**RE: Fiesta Kia Auto Group
7400 Lomas NE
Request for Certificate of Occupancy - Permanent
Hydrology Inspection - Approved
Grading and Drainage Plan Stamp Date: 6/13/18
Certification Dated: 4/5/19
Hydrology File: K19D152**

**RE: Fiesta Kia Auto Group
7400 Lomas NE
Request for Certificate of Occupancy - Temporary
Hydrology Inspection - Approved
Grading and Drainage Plan Stamp Date: 6/13/18
Certification Dated: 4/5/19
Hydrology File: K19D152**

1 SITE GRADING & DRAINAGE PLAN

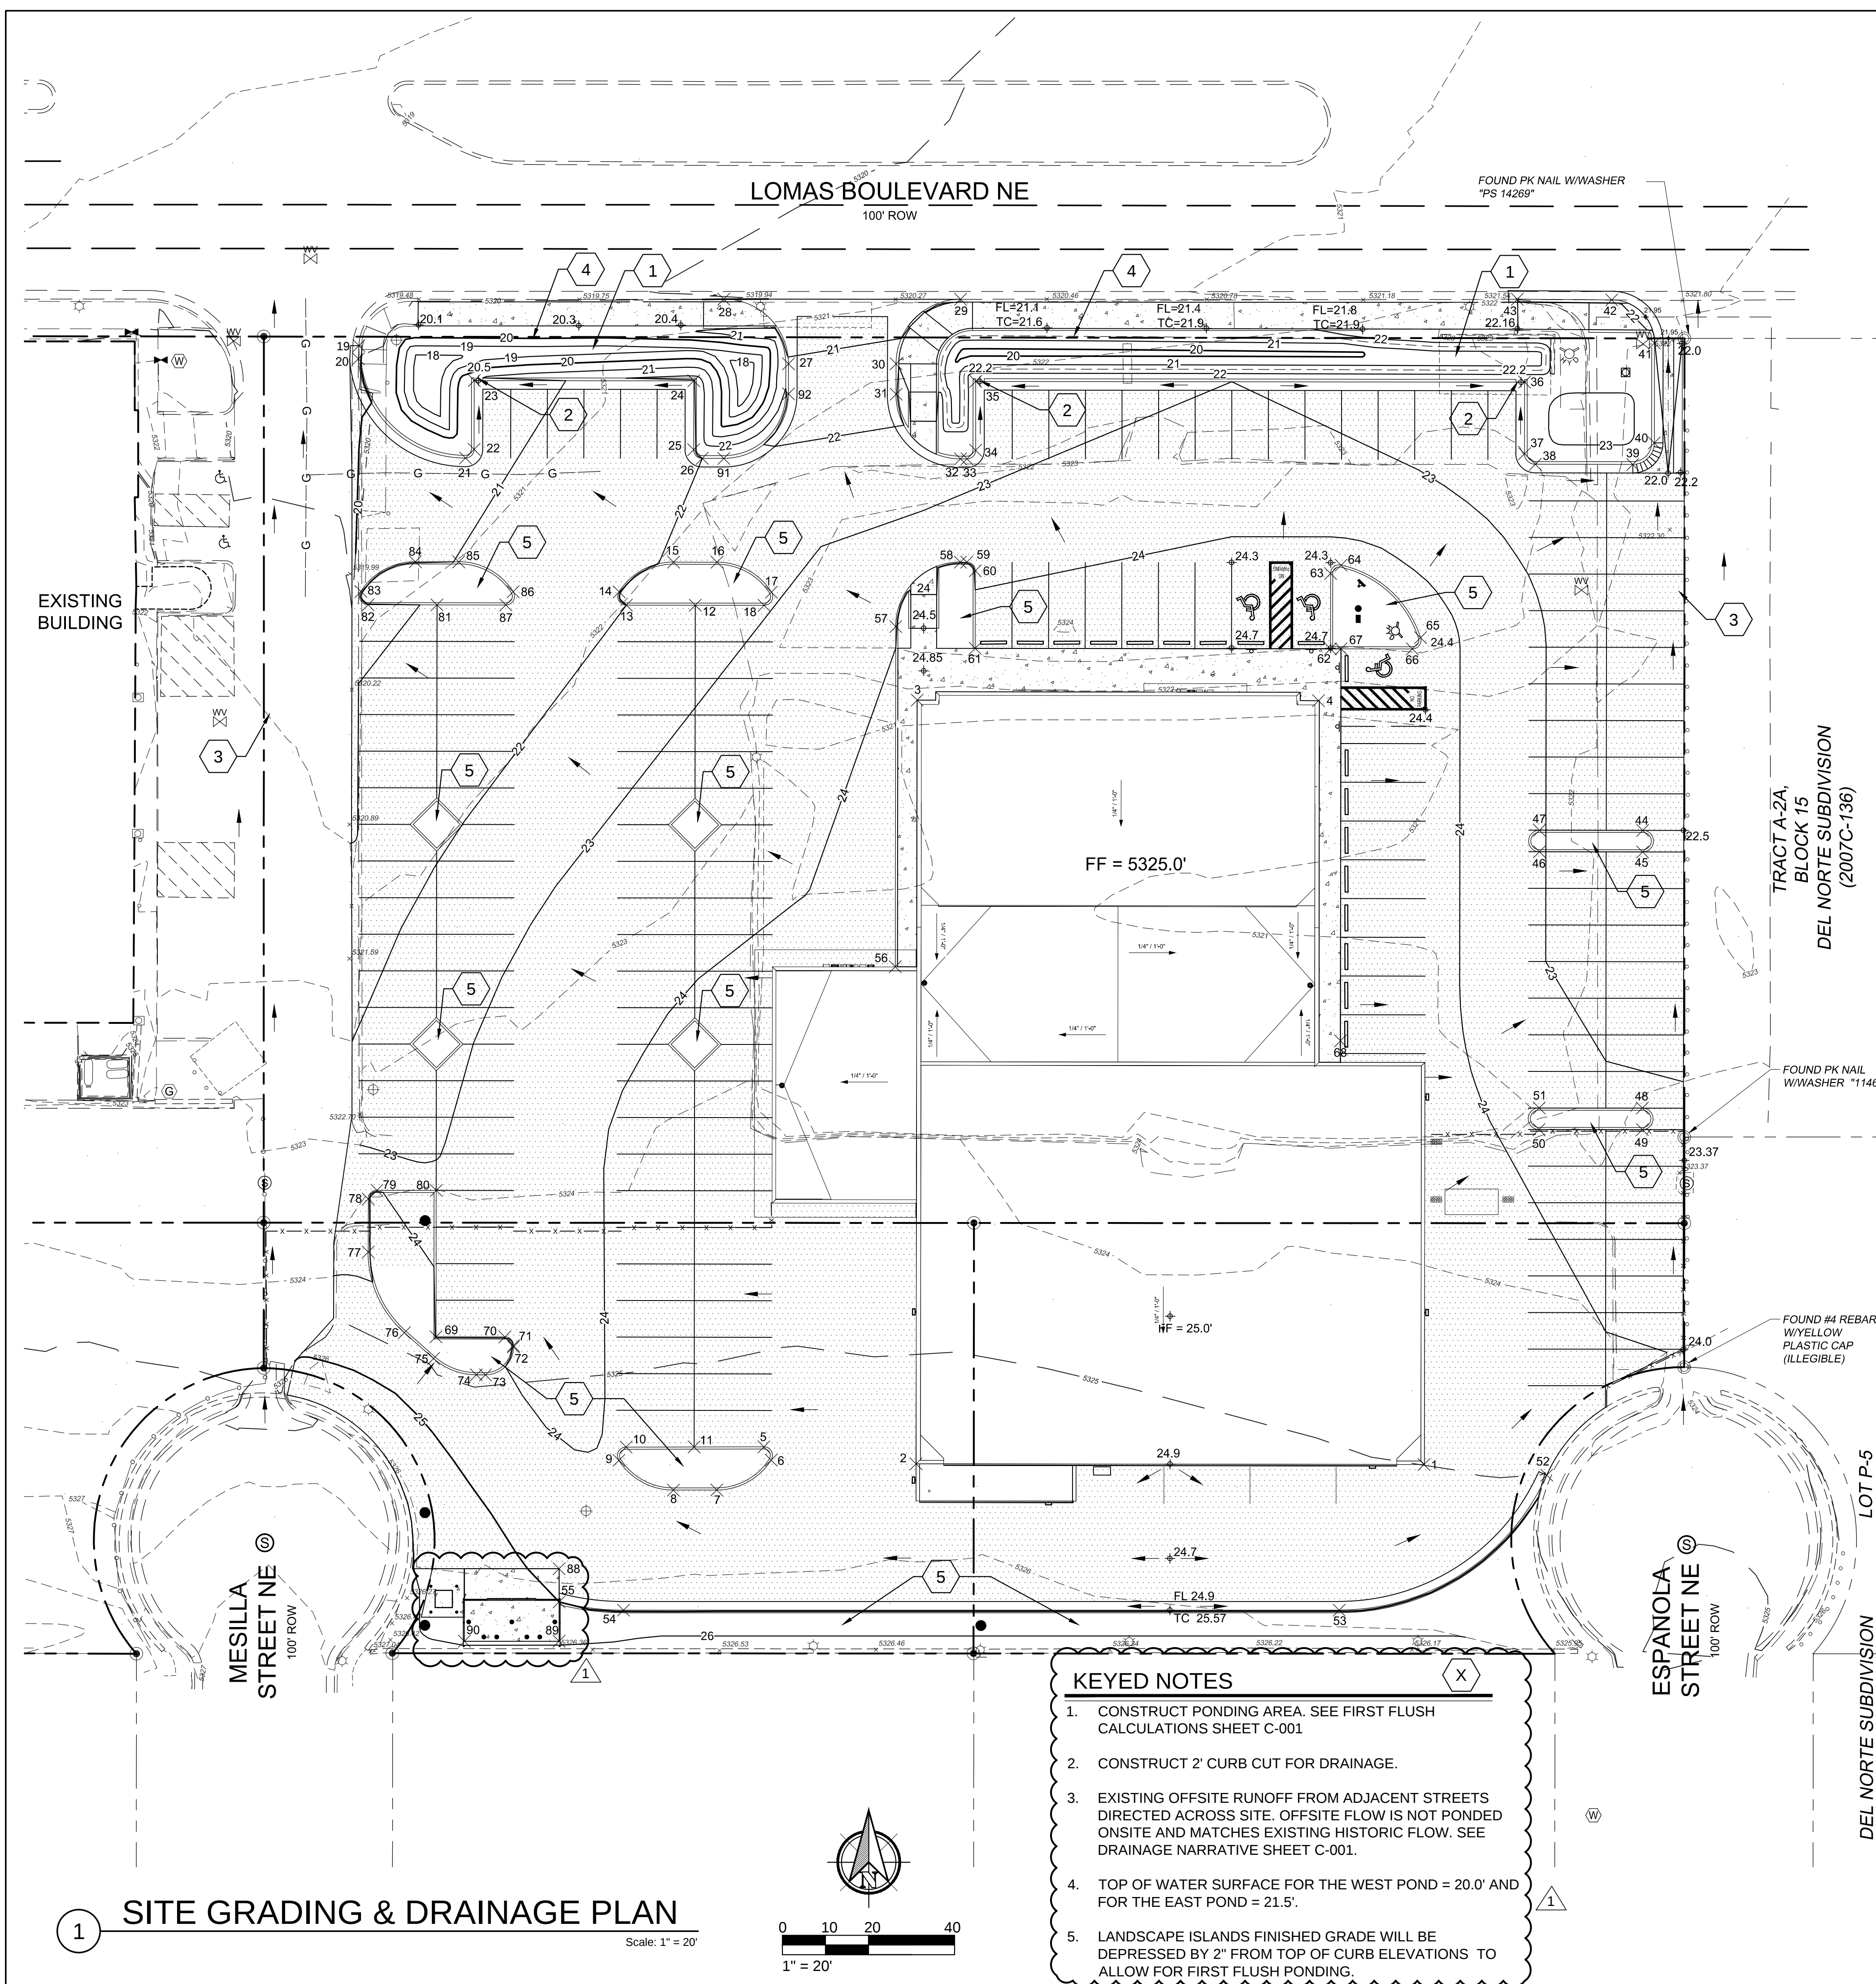
1. At the Mesilla St cul-de-sac, the CMU block knock-outs need to be lowered to match grade on the uphill side and the pavement on the downhill side needs to be formed into a swale and match grade with the knock-outs.
